A1 Birtley to Coal House

Scheme Number: TR010031

Statement of Common Ground with Gateshead Council

**STATEMENT OF COMMON GROUND
WITH GATESHEAD COUNCIL**

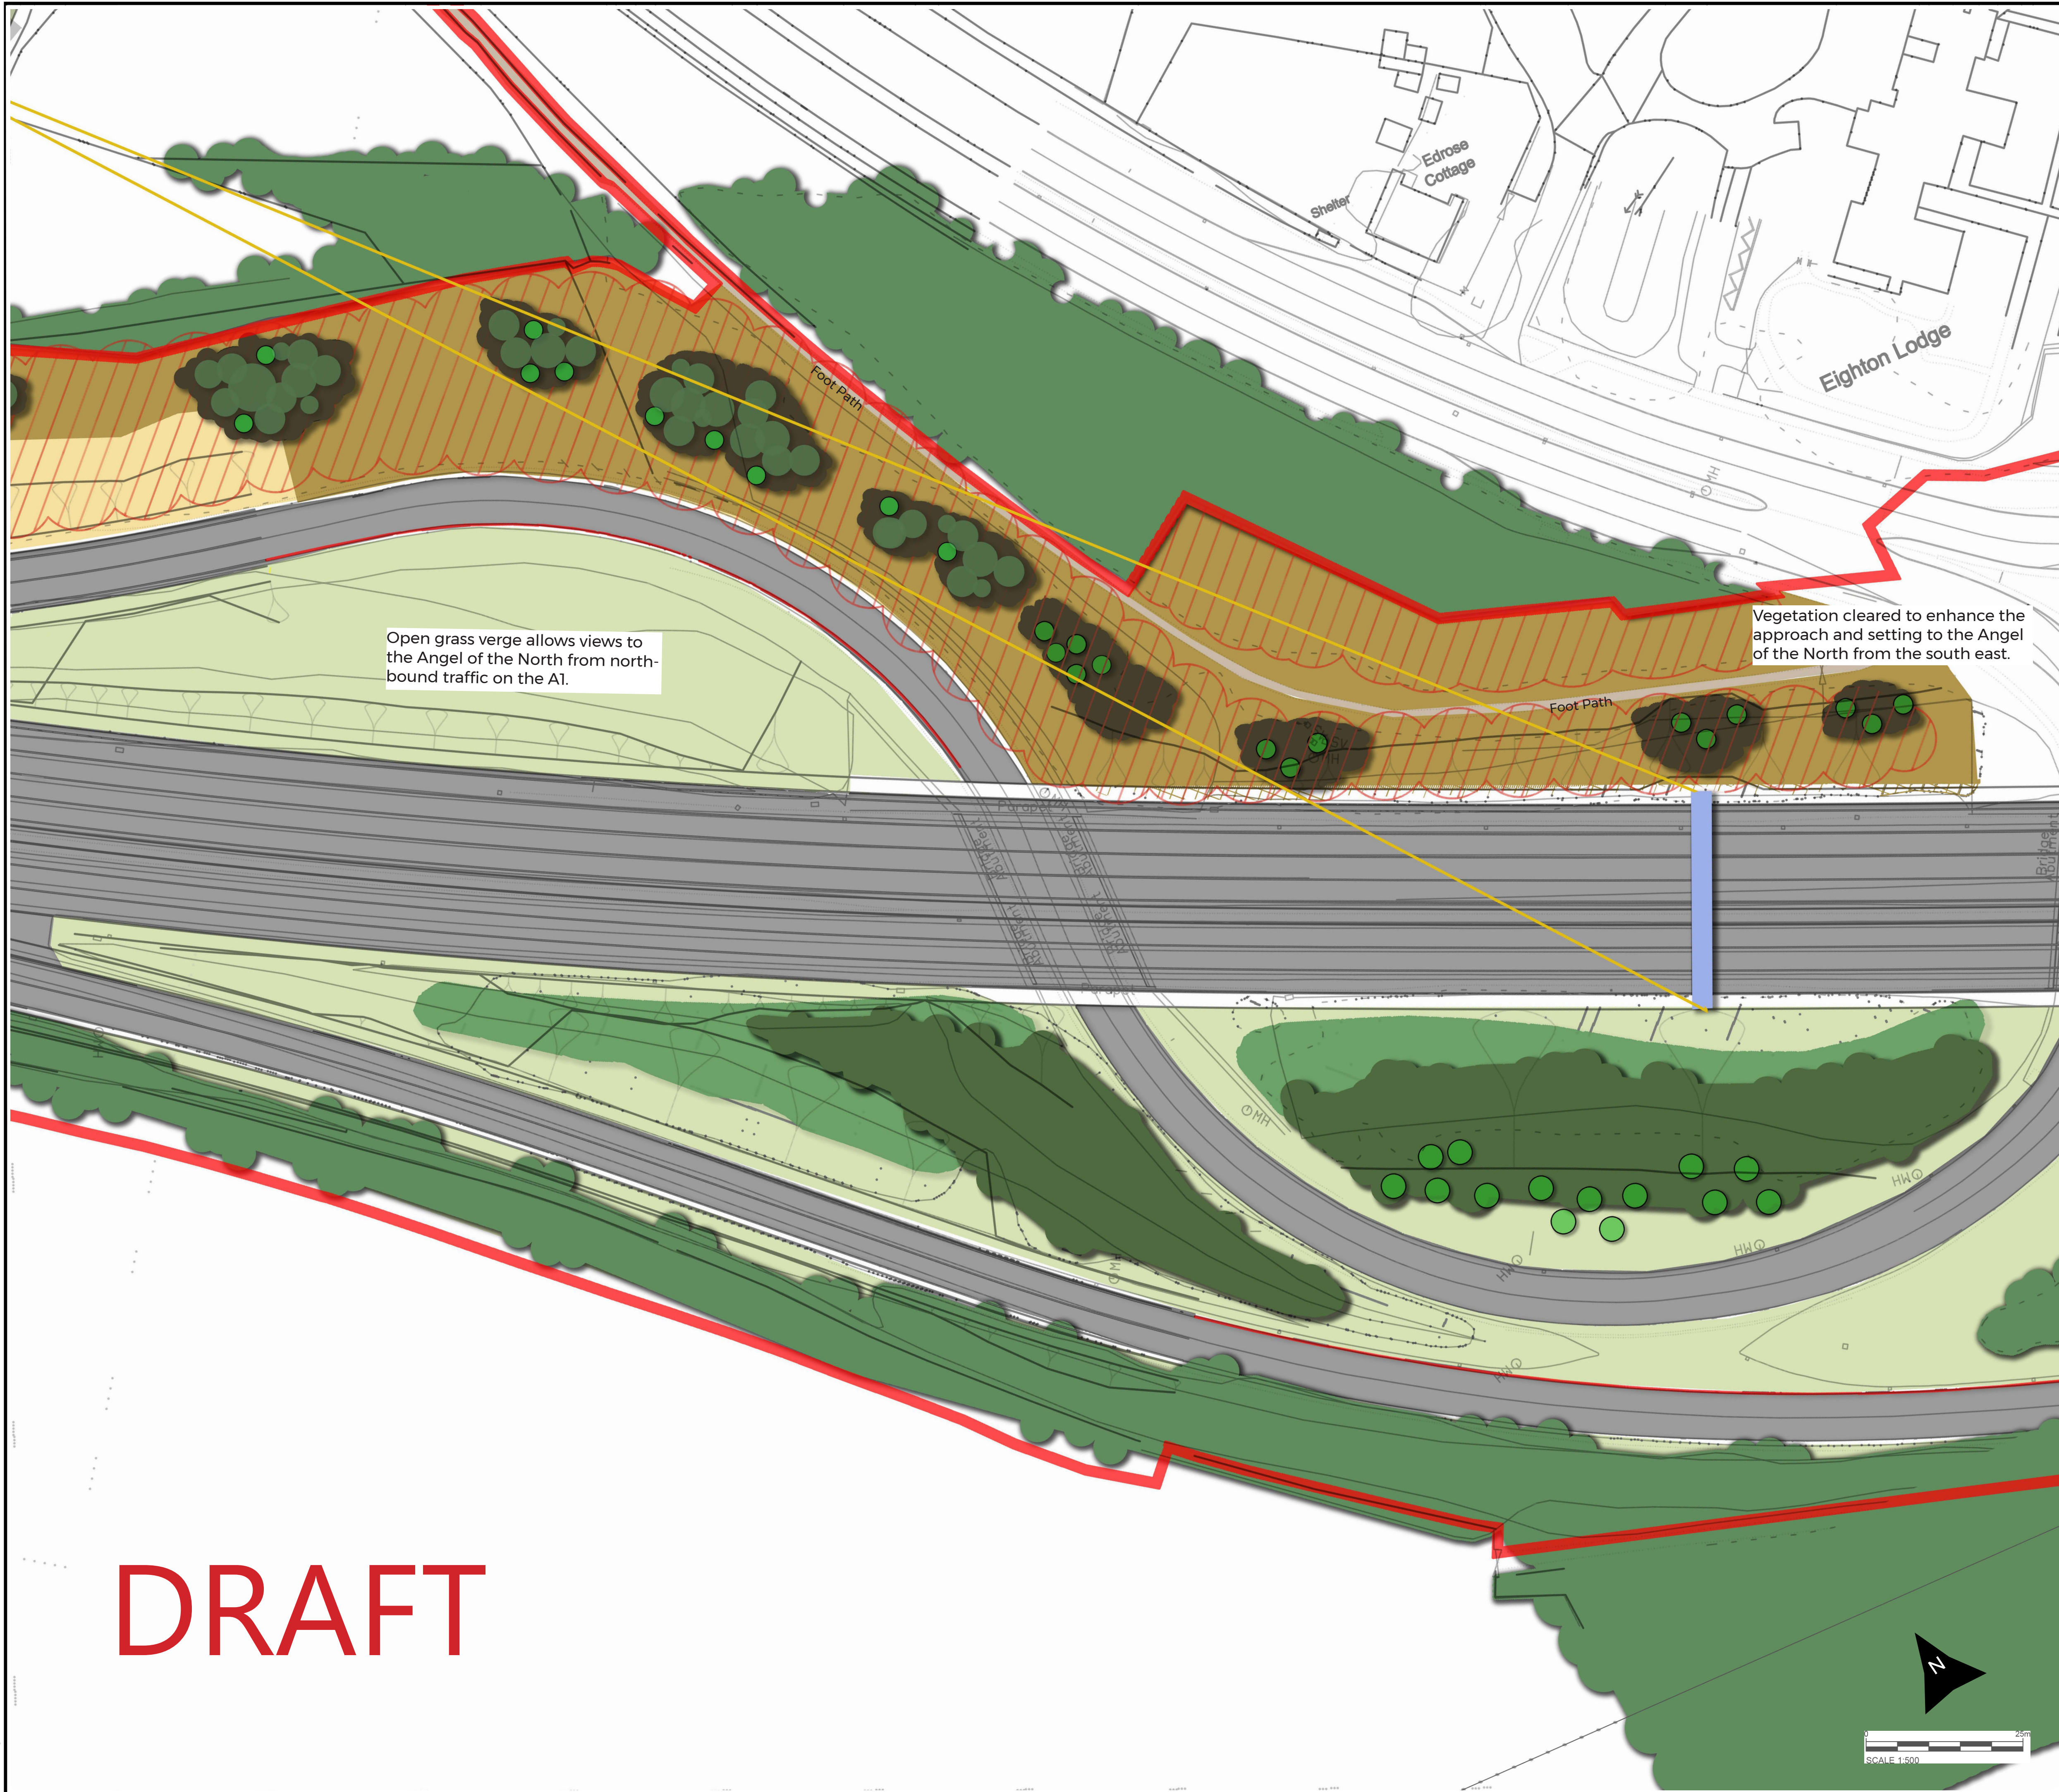
Section	Sub-section	Gateshead Council Position	Highways England Position	Status
Environmental Statement - Chapter 6: Cultural Heritage	6.8 Potential impacts	<p>At a meeting on Friday 3 July 2020, Gateshead Council confirmed that they are satisfied with the current landscape strategy as set out in Figure 7.6: Landscape Mitigation Design [APP-061].</p> <p>This agreement is on the understanding that the Applicant remains willing to continue without prejudice discussions on the potential implementation of a revised landscaping design for the area around the Angel of the North, as set out within the Southern Green Report [REP9-021]. Gateshead Council expressed preference is for Option 3: Revealing the Angel.</p> <p>Further to this meeting, Andrew Softley proposed (in an email to the ExA on 8 July 2020) an amendment to the Statement of Common Ground [REP9-023] that identifies design principles as set out below for the basis of further discussion at detailed design stage:</p> <ul style="list-style-type: none"> Replacing removed planting within an area to the south of the Allerdene Bridge crossing was undesirable, due to the proposed location's suitability for wading birds. 	<p>The Applicant considers that the current landscape strategy as set out in Figure 7.6: Landscape Mitigation Design [APP-061] delivers the requirements of the Scheme and appropriately mitigates the effects thereof.</p> <p>Notwithstanding the above, the Applicant notes Gateshead Council's aspiration to deliver Option 3: Revealing the Angel of the North within the Southern Green Report [REP9-021], however, the Applicant's preferred option would be Option 1 or 2. Nevertheless, the Applicant is willing to continue without prejudice discussions with Gateshead Council, beyond the examination period, to identify how Option 3: Revealing the Angel, or a version of it could be delivered as part of the Scheme. Further discussions, to be carried out as part of the detailed design phase, will be based on the principles as proposed by Andrew Softley in an email dated 7th July 2020 [REP9-023].</p> <p>It is, therefore, agreed that Figure 7.6:</p>	Agreed

Section	Sub-section	Gateshead Council Position	Highways England Position	Status
		<p>gantries will be significant</p> <p>Gateshead Council has advised that their concerns on this matter have been reduced sufficiently to accept Figure 7.6: Landscape Mitigation Design [APP-061] as the DCO Scheme whilst progressing non-prejudice discussions on the principles set out in the email dated 7 July 2020, from Andrew Softley have been agreed.</p>	<p>Response to the ExA's Second Written Questions addresses the effect that these gantries will have on views of the Angel of the North and confirms that the effect of the installation of the gantries on the Angel of the North would not be significant.</p> <p>As stated above, the Applicant is willing to continue without prejudice discussions with Gateshead Council, beyond the examination period, based on the principles as proposed by Andrew Softley in an email dated 7 July 2020 [REP9-023].</p>
